**Re: Tidal Wave Auto Spa**  
**10601 Unser Blvd. NW**  
**Traffic Circulation Layout**  
 Architect's Stamp 03-20-23 (A11-D017C)

Based upon the information provided in your submittal received 03-21-23, the above referenced plan cannot be approved for Building Permit until the following comments are addressed:

AS101

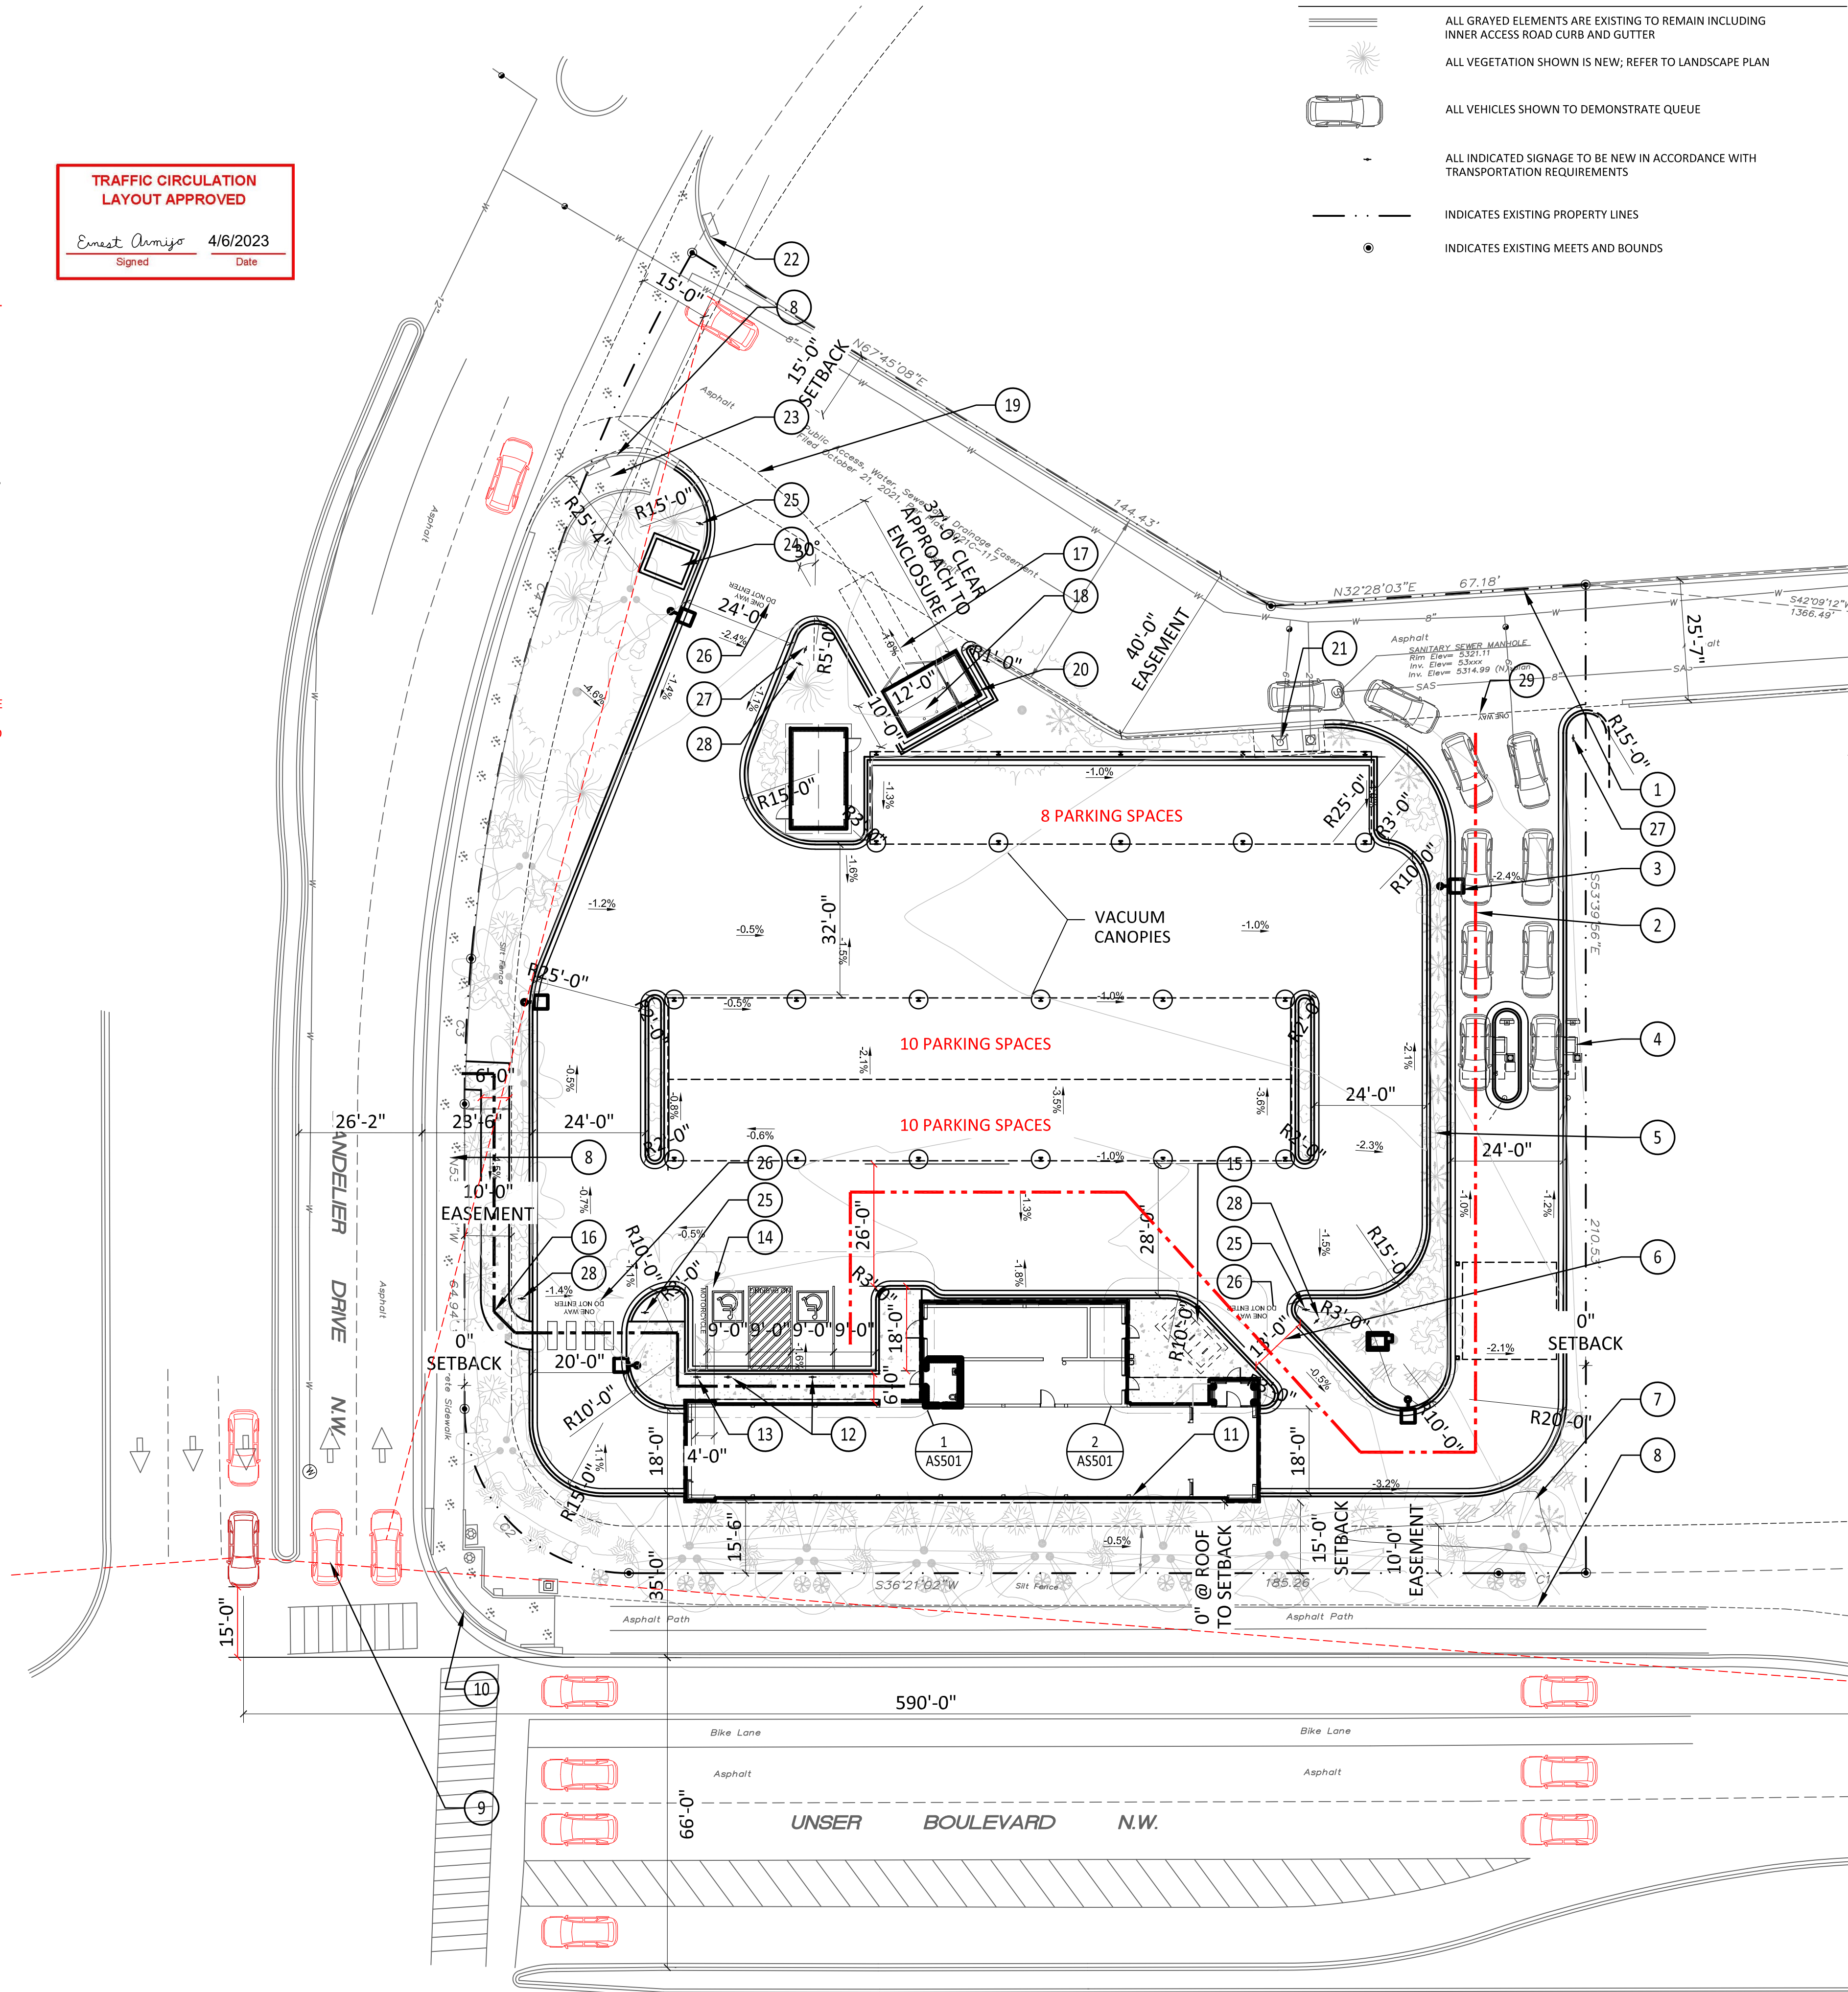
1. Please provide a standard parking space. Providing only ADA parking is not allowed.
2. Rolled Curb is not permitted on the ADA pathway. Either flush or an ADA ramps should be provided.
3. Please provide "One Way" pavement marking on the beginning of the drive-thru.

4. Please provide “STOP” and “Do Not Enter” signs and pavement marking for all the proposed one-way drive lanes.

5. The site plan doesn't show how the employee could enter to the site. Please show on the site plan logical pattern that the employee can easily understand and follow.

6. Please provide Bike Rack per city new requirements. See attached.
  7. Show on the site plan the Intersection clear sight triangle for the site access off Bandelier Dr. NW.

8. Please specify the City Standard Drawing Number when applicable.
  9. Add a note stating "All broken or cracked sidewalk must be replaced with sidewalk and curb & gutter." A build note must be provided referring to the appropriate City Standard drawing.
